KITTITAS COUNTY FIRE MARSHAL'S OFFICE

July 1, 2010

Re: Haberman (BL-10-00023)

Proposed Boundary

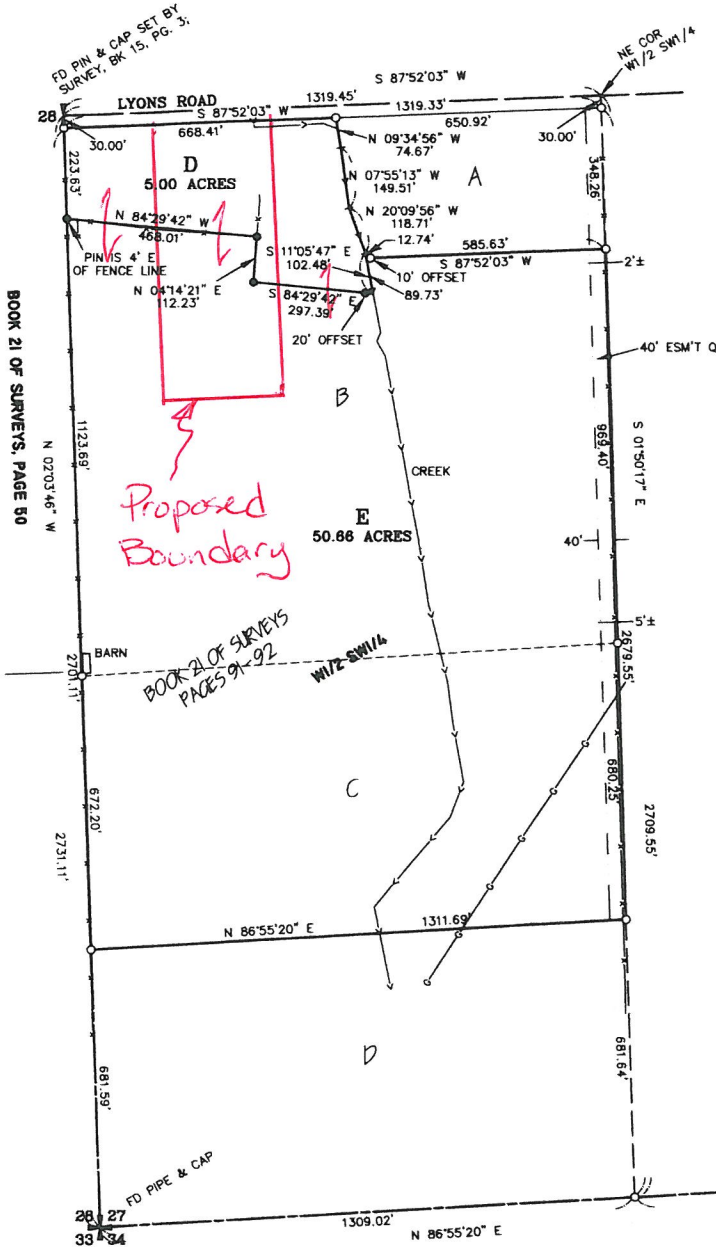
- Ensure that boundary line adjustments do not infringe upon existing structures, to include propane tanks, etc.
- All future development must comply with the International Fire Code.
